**From:** [HOLMES, Steven](#)  
**To:** [Keuper Gas Storage Project](#)  
**Cc:** [REDACTED]  
**Subject:** Response to Second Round of Questions  
**Date:** 05 July 2016 16:48:29

**Question 1.6**

**Question 5.2.9**

HOLFORD BRINEFIELD - KGSP - DEVELOPMENT AT WELLHEAD H502

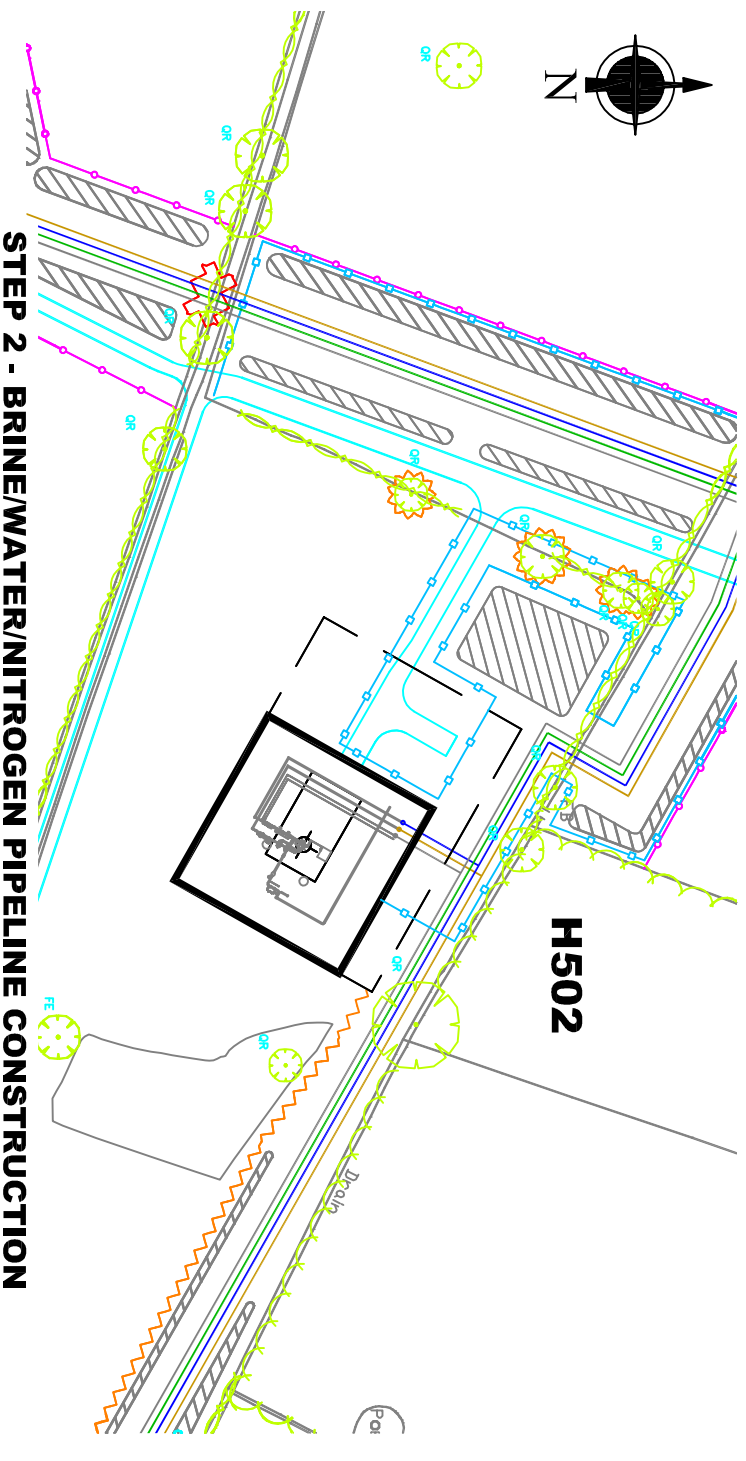
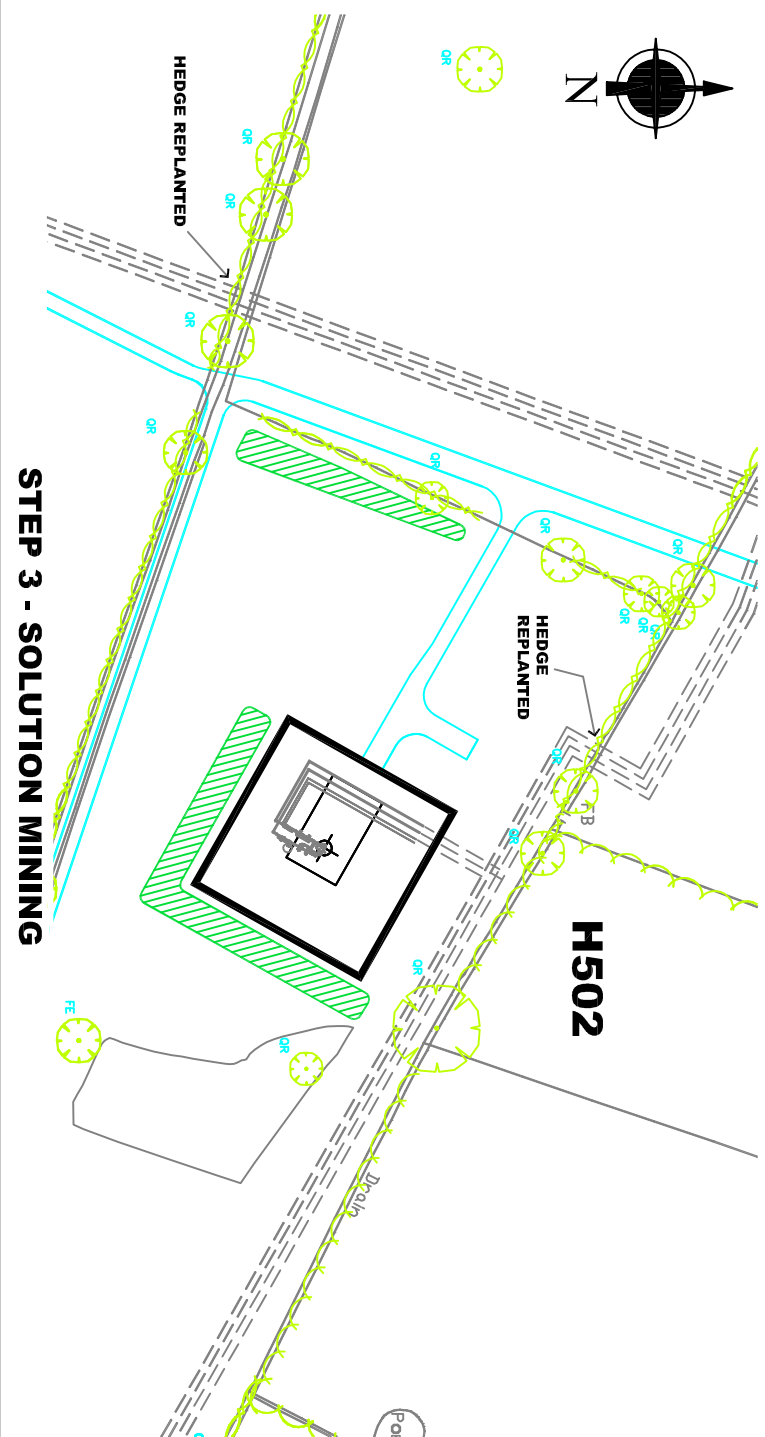
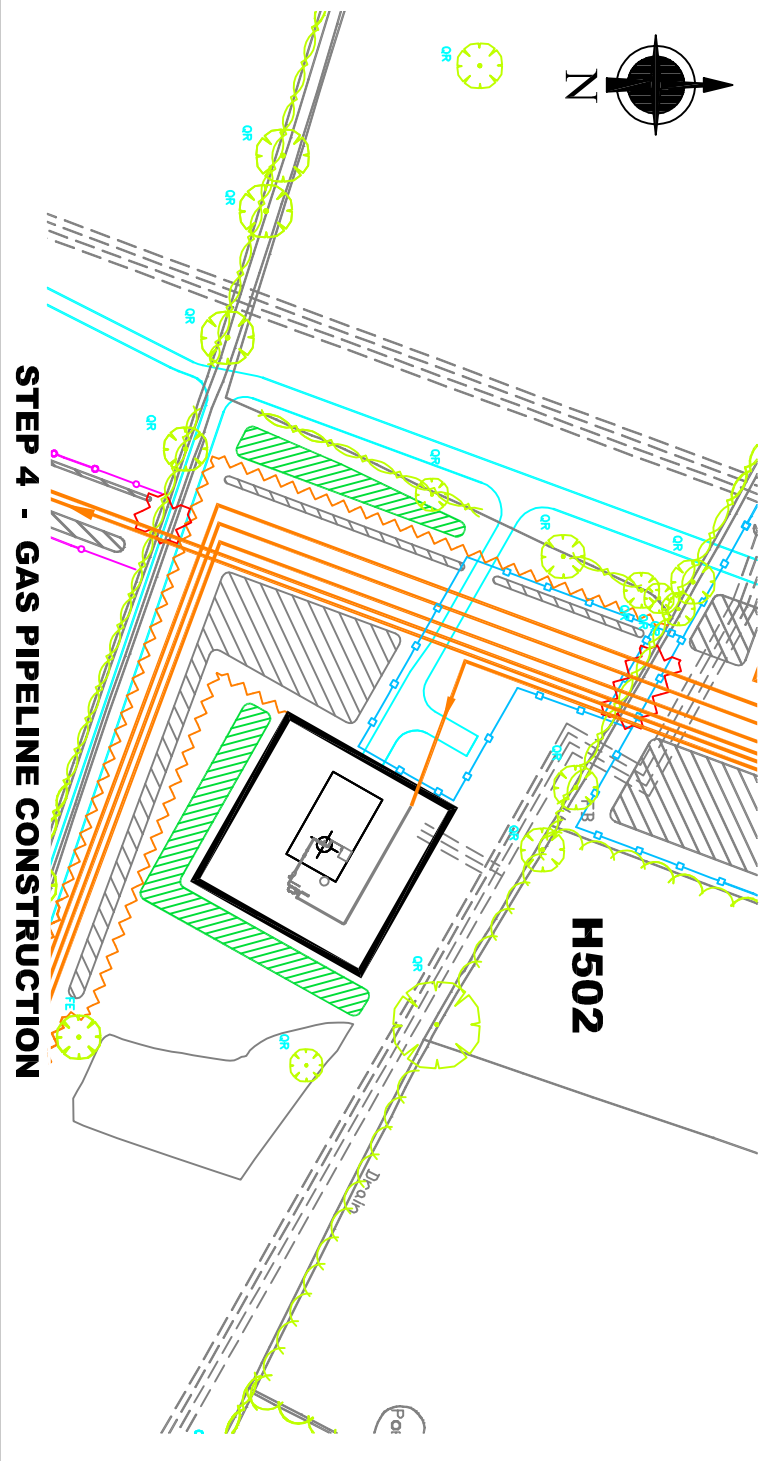
The LPA would still expect that the appropriate phasing of the development should form part of any noise attenuation as it would consider it unacceptable for long periods of drilling activity to take place at the levels expressed the ES further to the comments made in the written representation at paragraphs 15-17 of its written representation and paragraph 16 of its comments of its later submission 7 June. The LPA is continuing to work with the applicant to agree an appropriate mitigation strategy but considers that the CEMP will need to be amended to reflect the outcome of these discussions.
